TO: All Staff
FROM: Kelee Hodges, Engineer Tech II on behalf of Justin Turnbull, County Surveyor
DATE: March 31, 2022
SUBJECT: County Survey Review of BL-22-00004 Burke

Survey Comments:

PART OF THE SOUTHEAST QUARTER OF SECTION 28, TOWNSHIP 17 NORTH, RANGE 19 EAST, W.M.

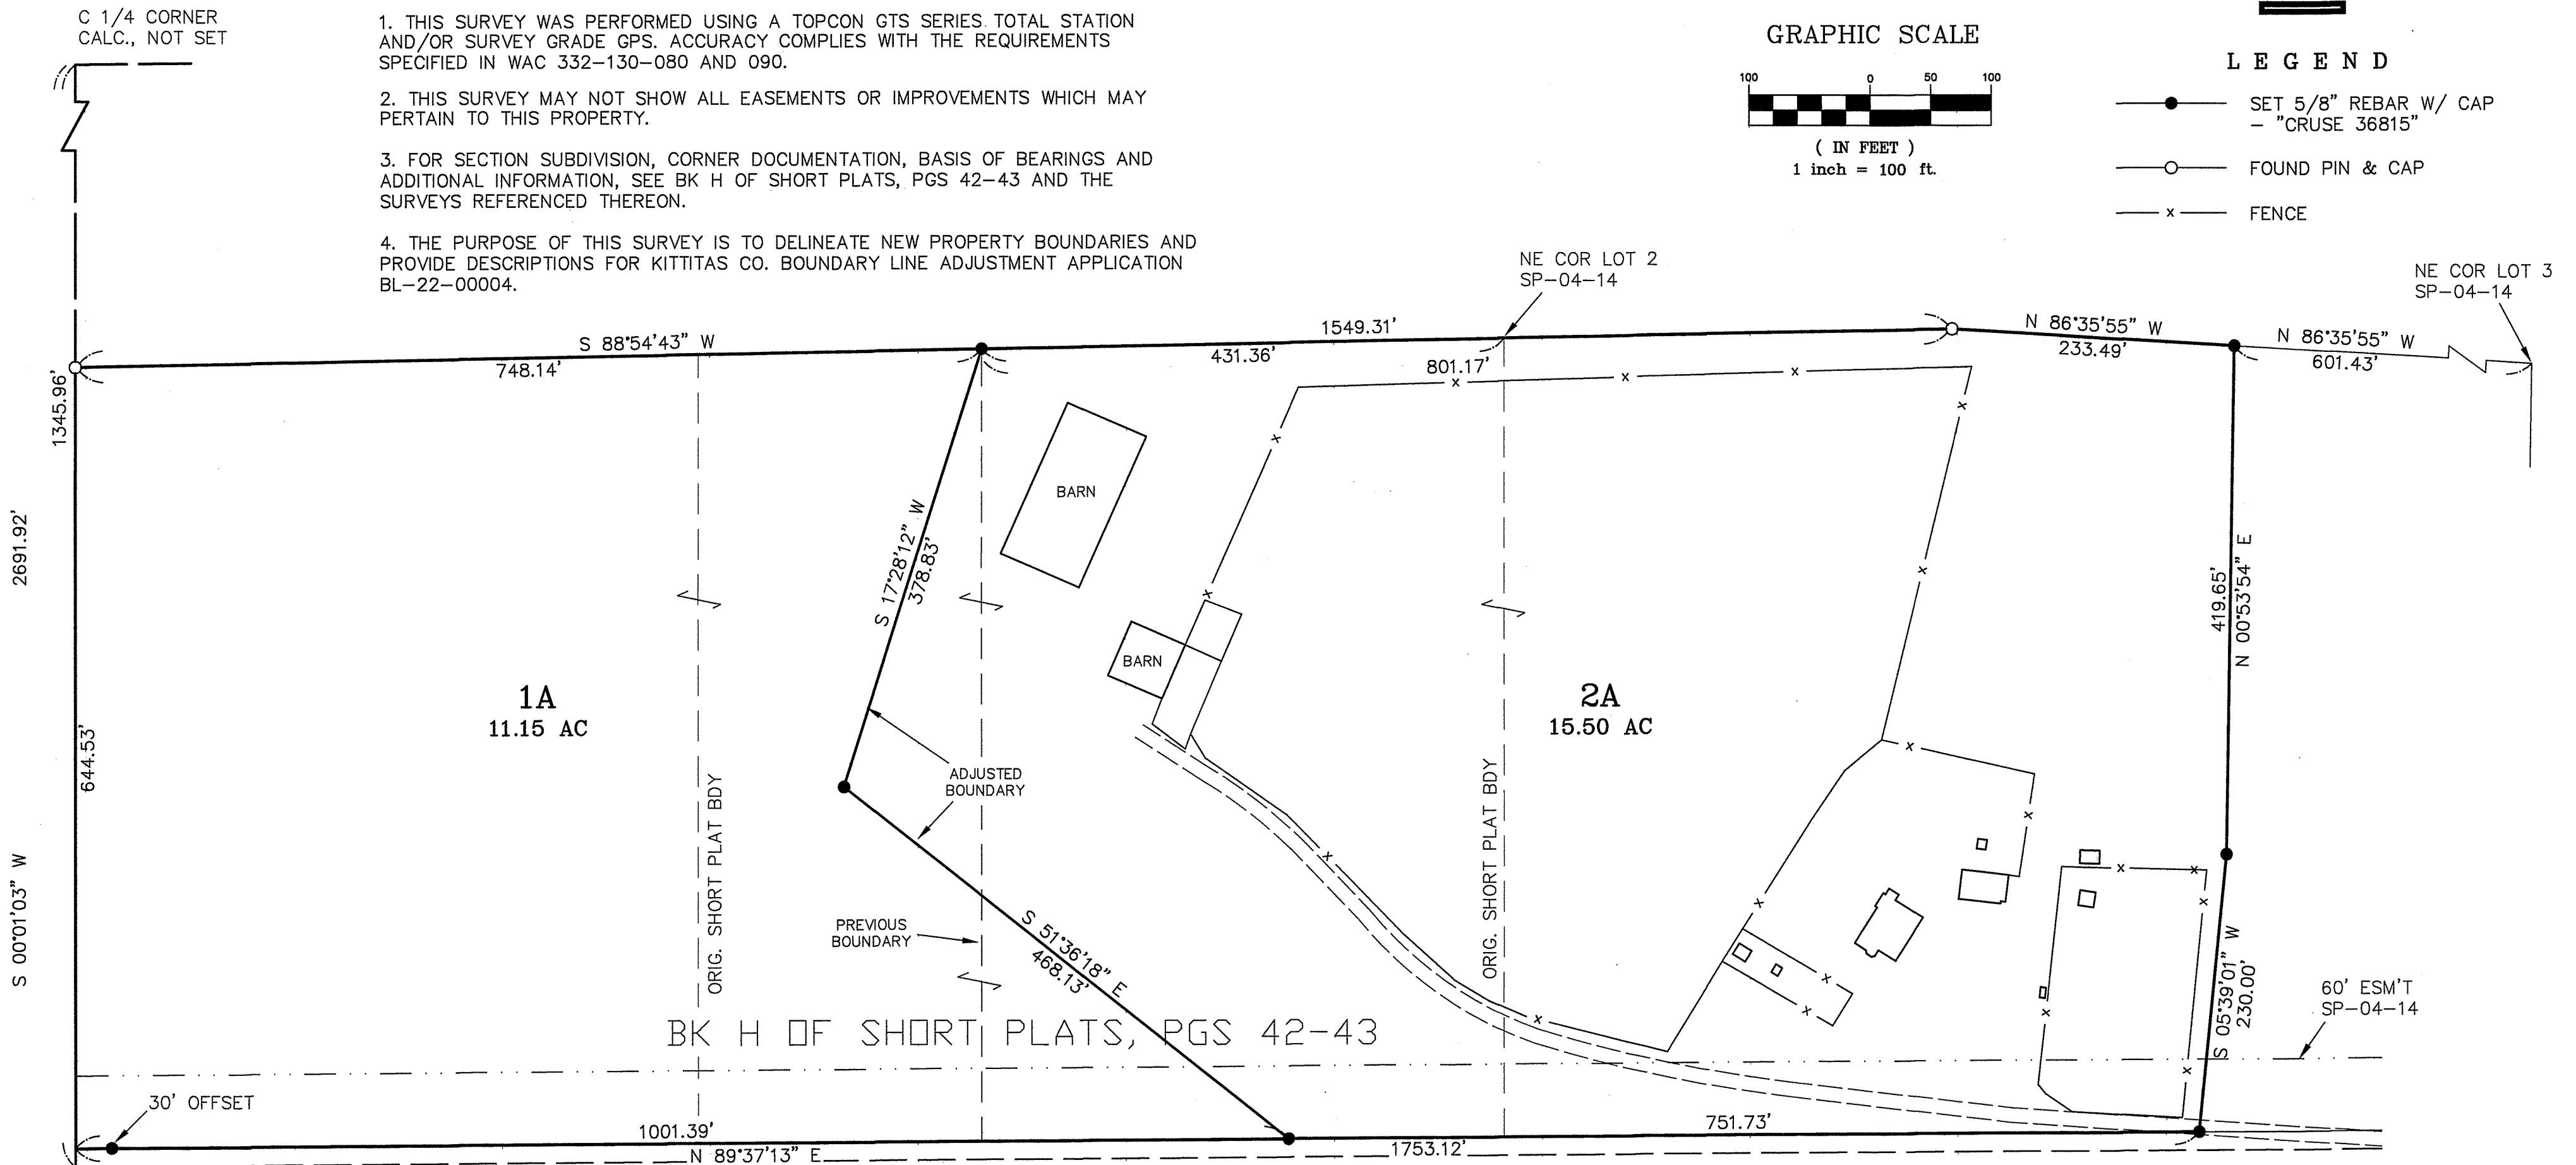
1. All easements must be labeled as "Existing" or "Created via Separate Document" as well as show the recording number, width, and type of easement.
 - a. 60' Access easement needs to reference either the Short Plat book and page or the AFN.
